From: [REDACTED]
Sent: 13 June 2022 15:06
To: Salam, Kabier - Oxfordshire County Council
Cc: Kelvin Pearce; [REDACTED]; James Griffiths; Emma Lancaster; Johnathan Welton; Caroline Ford
Subject: AXIS J9, HOWES LANE, BICESTER – PHASE 3
Attachments: 211014 - Planning Response CDC Land Drainage (1).pdf; 220203 - Planning Response CDC Land Drainage (2).pdf; 220406 - Planning Response CDC Land Drainage (3).pdf; 220506 - Planning Response CDC Land Drainage (4).pdf; S1209 - PH3 - 02G - Phase 3 SW Drainage Layout.pdf; S1209 - PH3 - DD01C - Phase 3 Drained Areas.pdf; S1209 - PH3 - 06 - Phase 3 Swale 1 Details.pdf; S1209 - PH3 - 07 - Phase 3 Swale 2 Details.pdf; S1209 - PH3 - DD05 - Construction Phasing Plan.pdf

S1209/220613em/WB/LDD

**Re: AXIS J9, HOWES LANE, BICESTER – PHASE 3
PLANNING APPLICATION NO 21/03177/F**

Swale 1 Plan 1:250

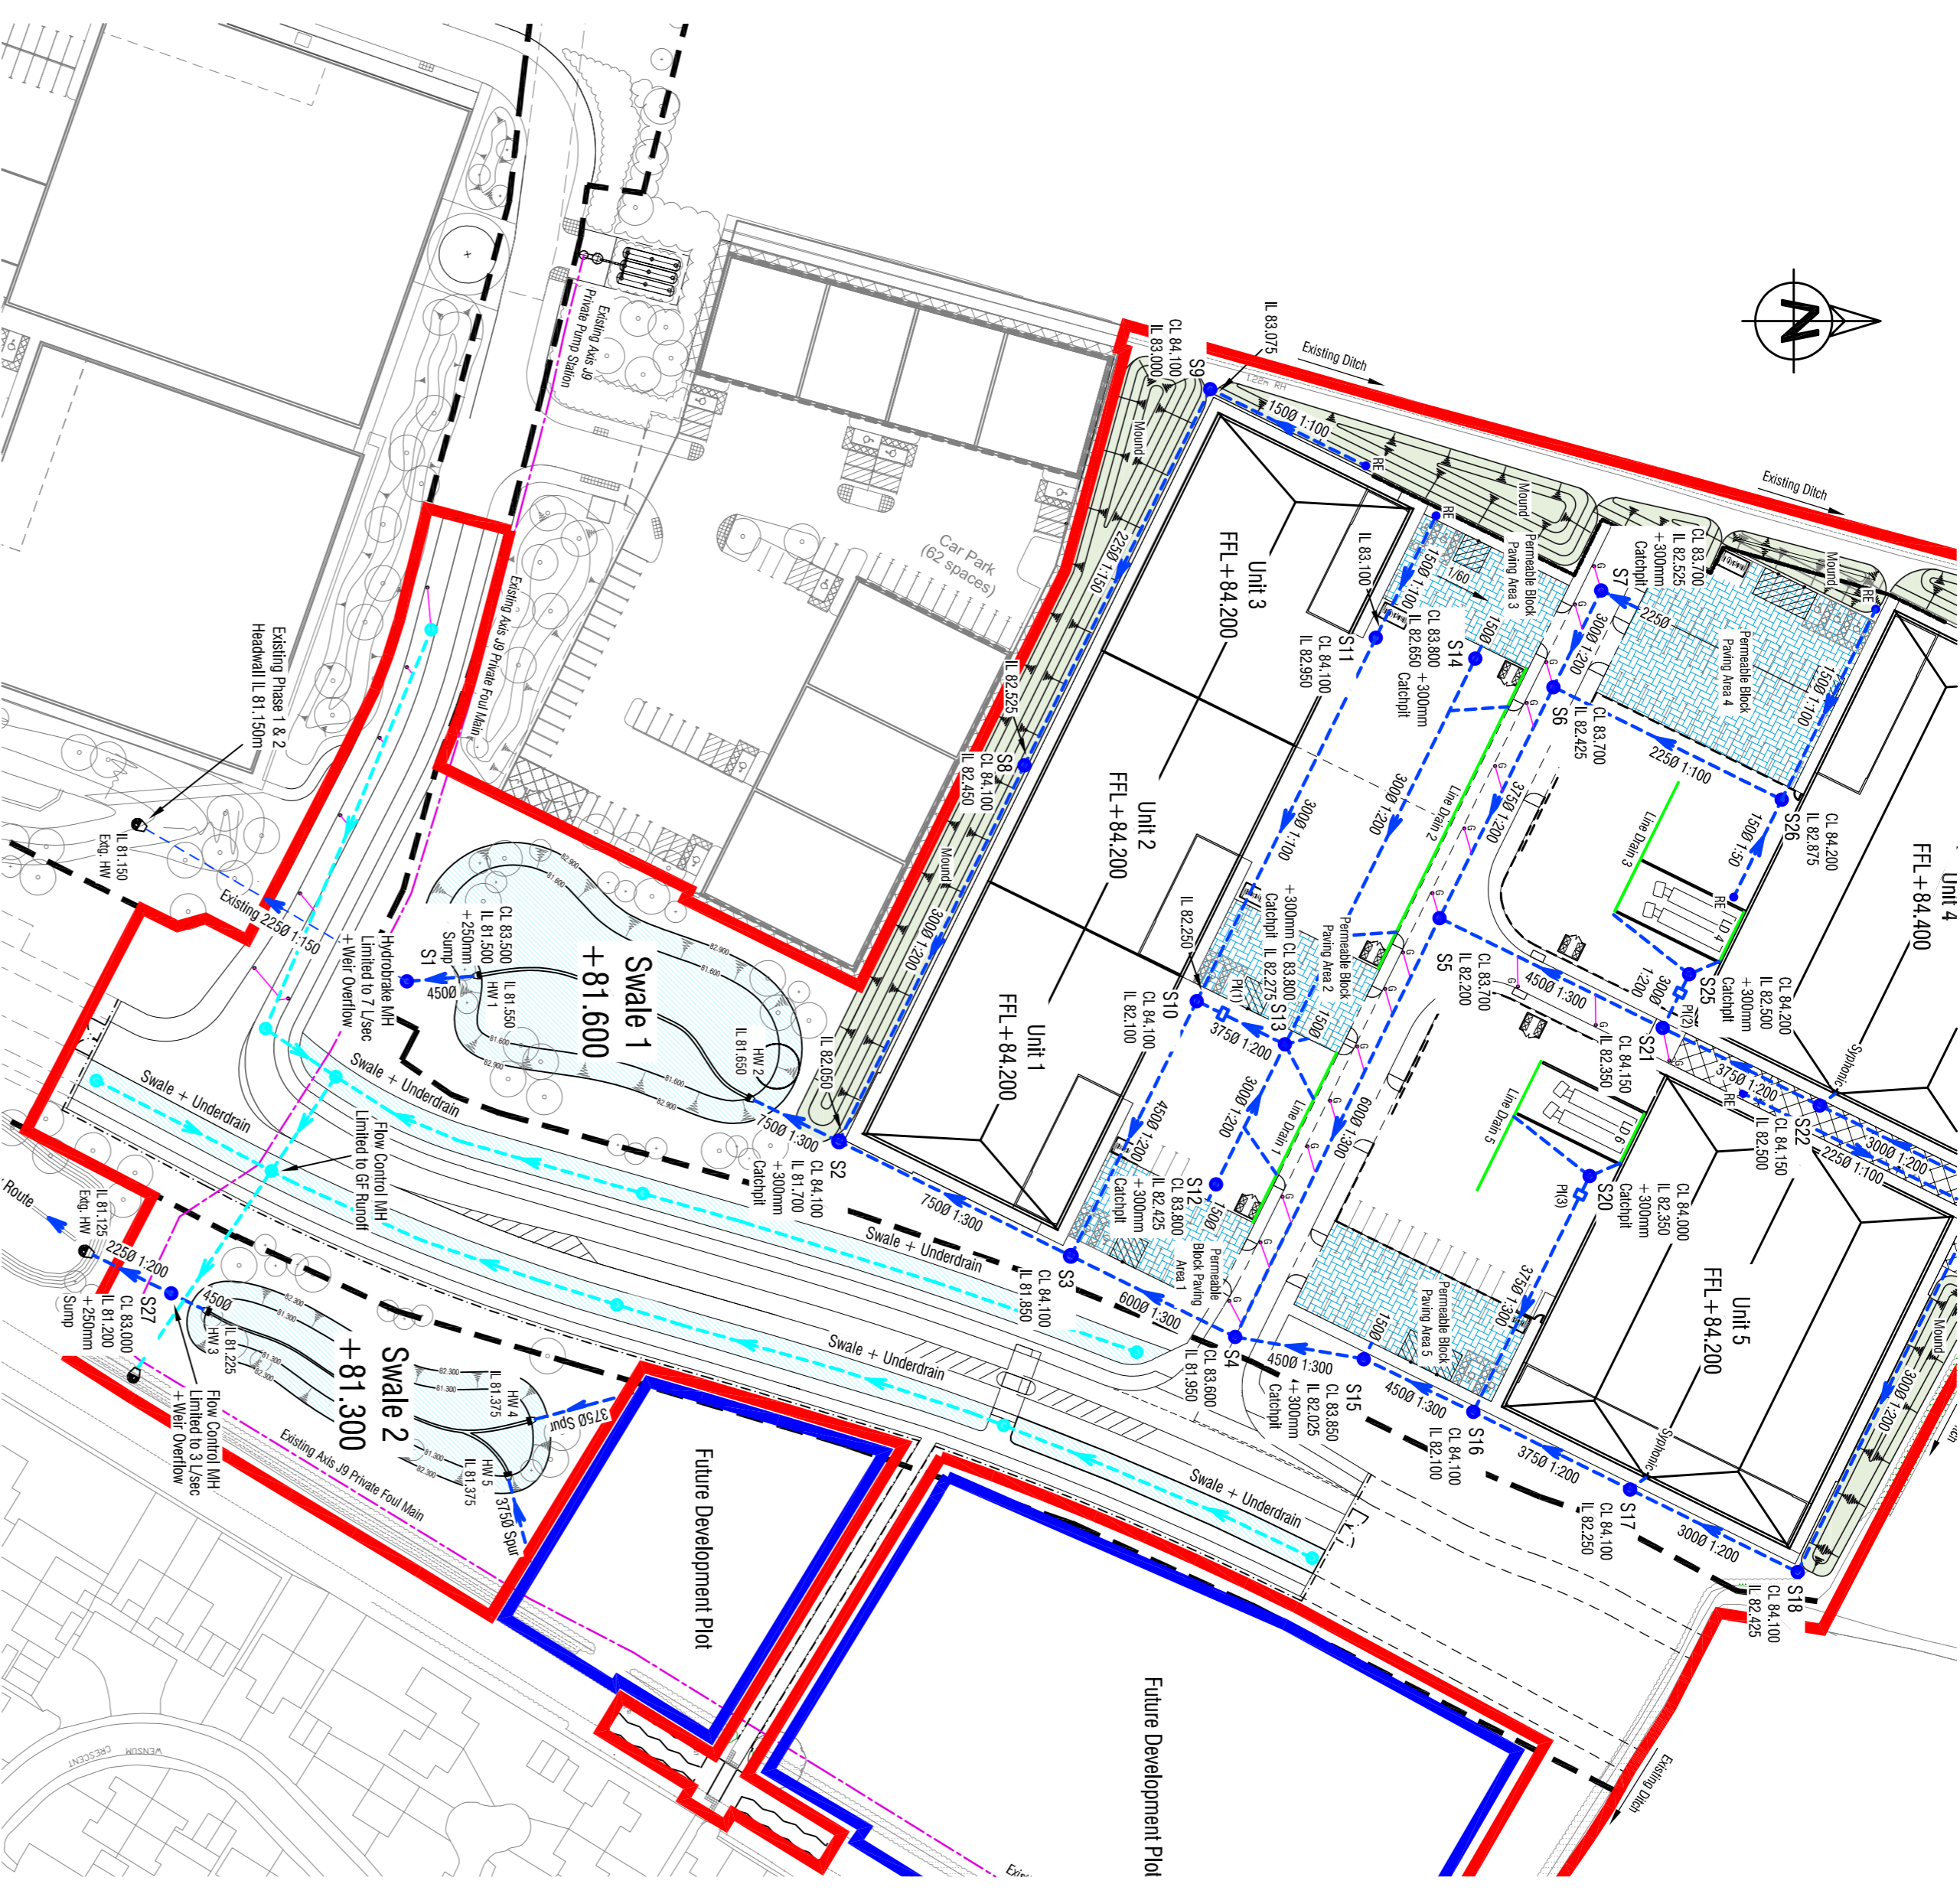
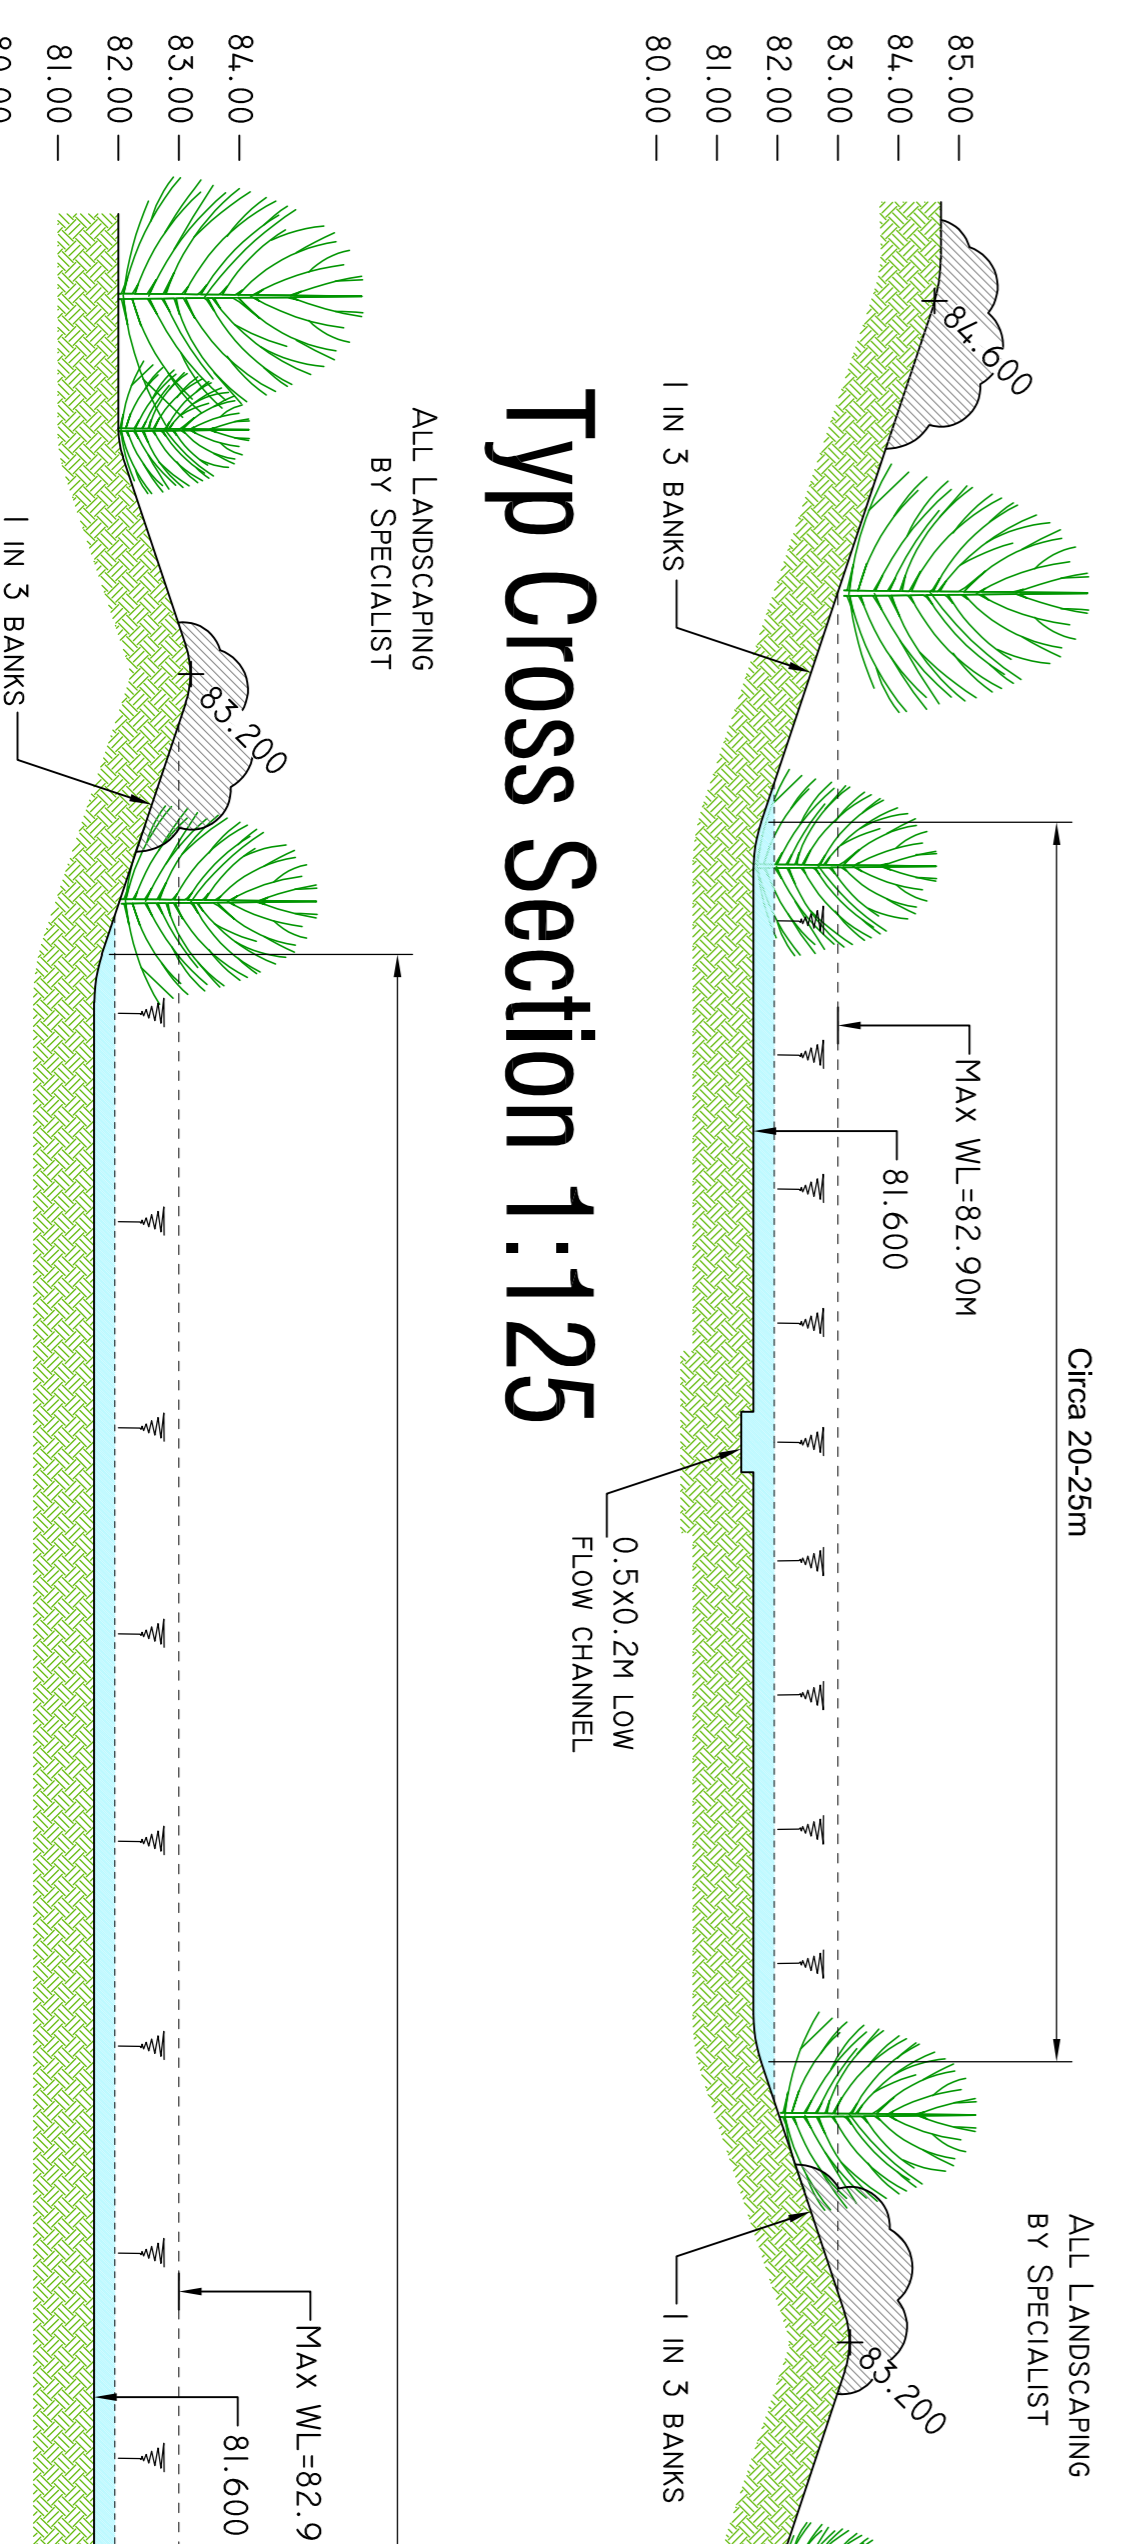
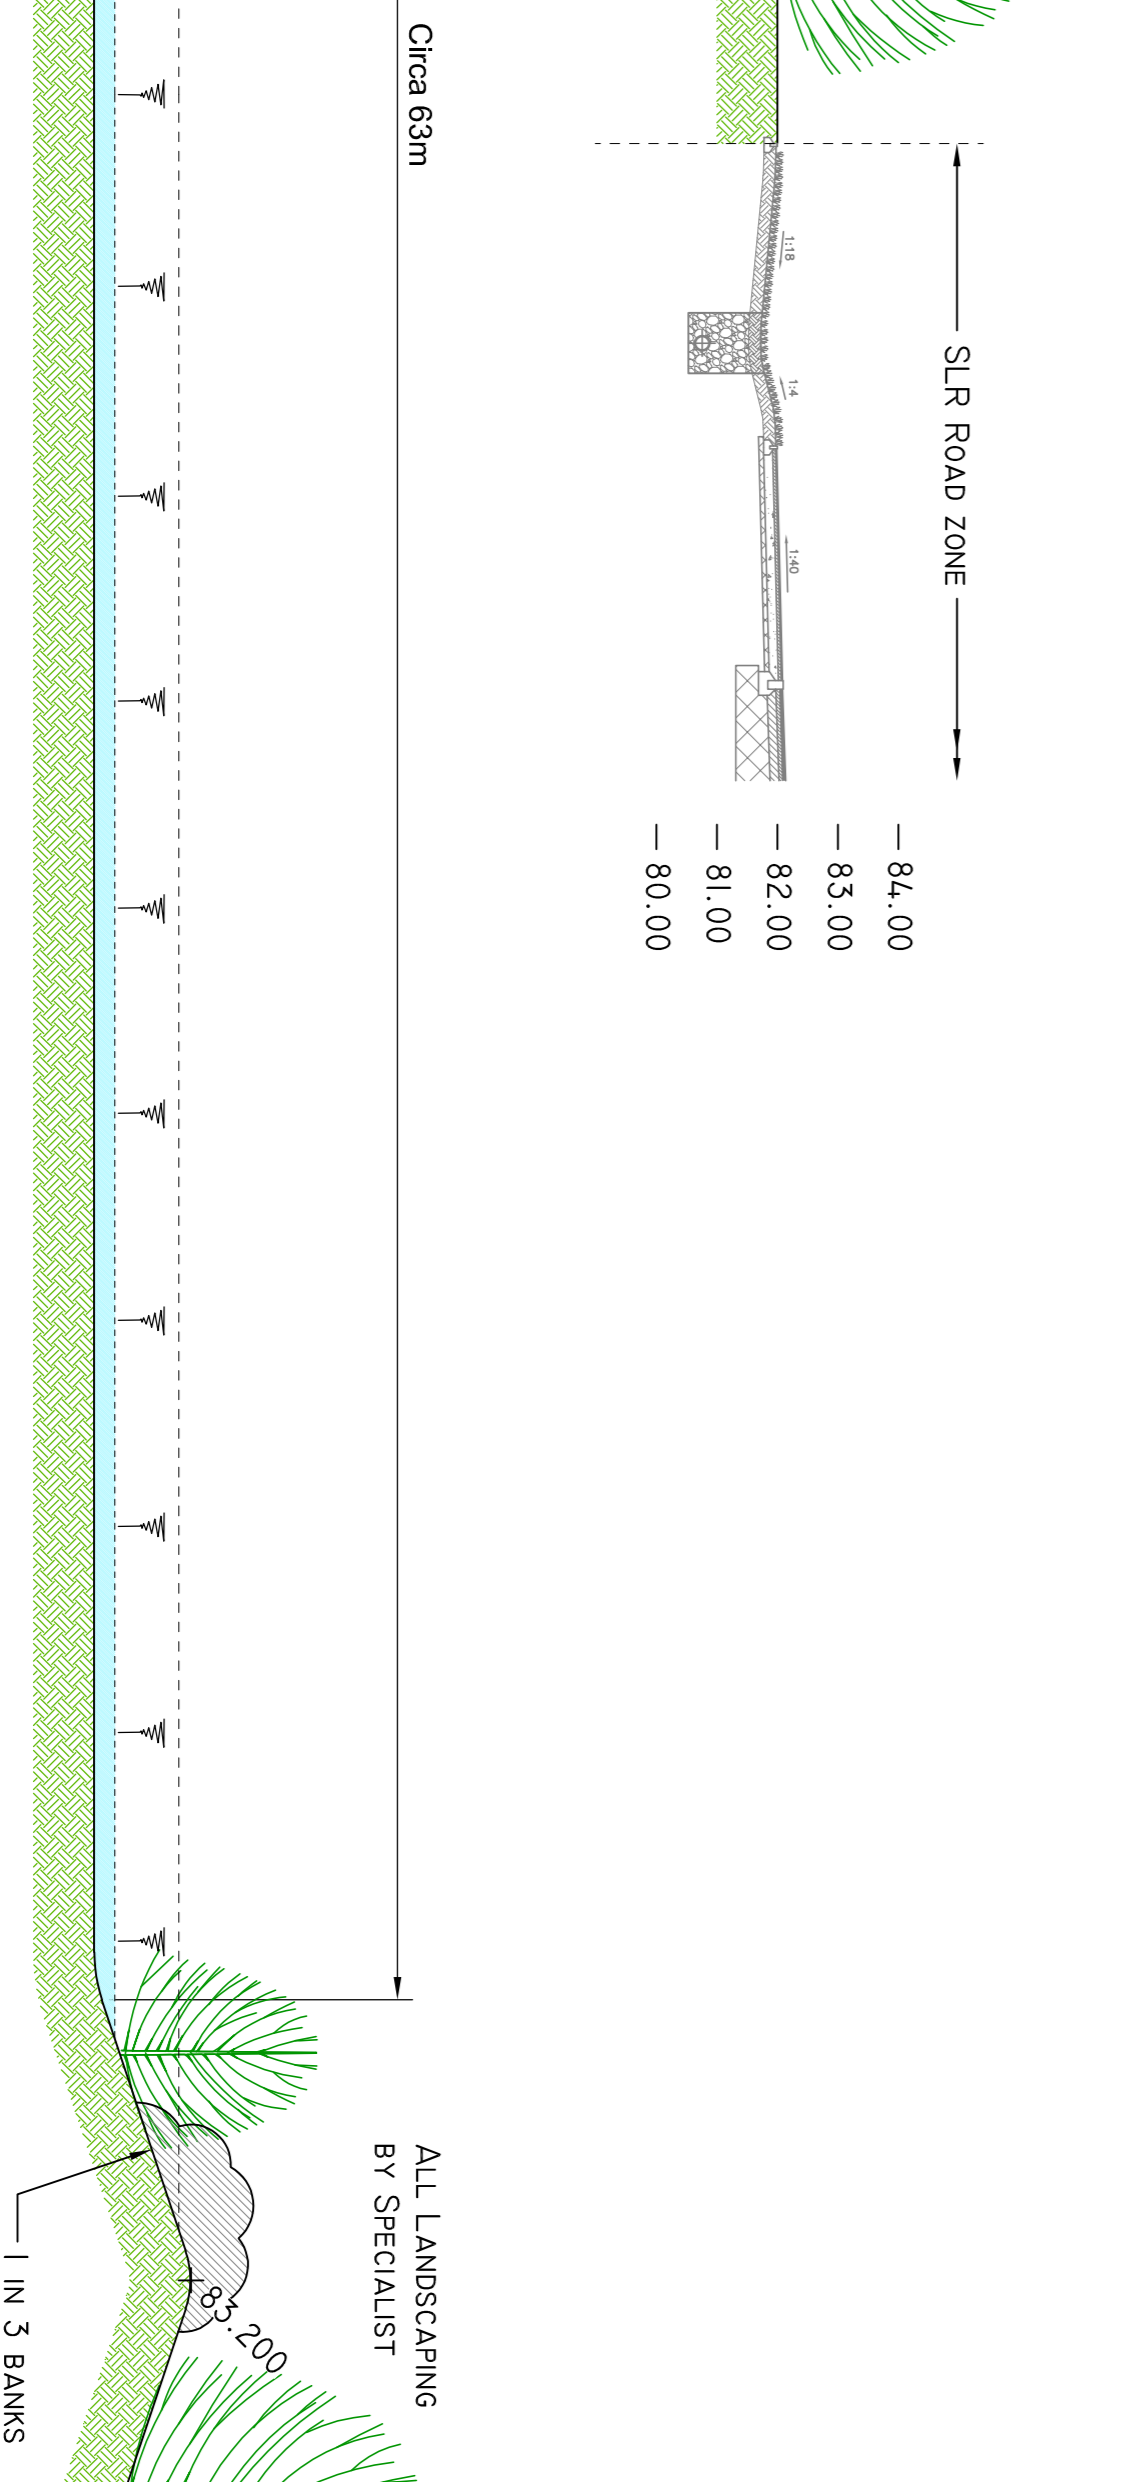
Our revised Drawings S1209-PH3-02G and S1209-PH3-DD01C are now attached to clarify.
- **DRAINAGE STRATEGY WITHIN APPLICATION BOUNDARY**
 - Units 1, 2, 3, 4 and 5 will be drained into Swale 1.
 - The SLR/Bus route will drain to the existing ditch alongside Howes Lane.
 - Future development will drain into Swale 2.
 - I attach enlarged Plans of Swales 1 and 2 to clarify, Drawings numbered S1209-PH3-06 and S1209-PH3-07.
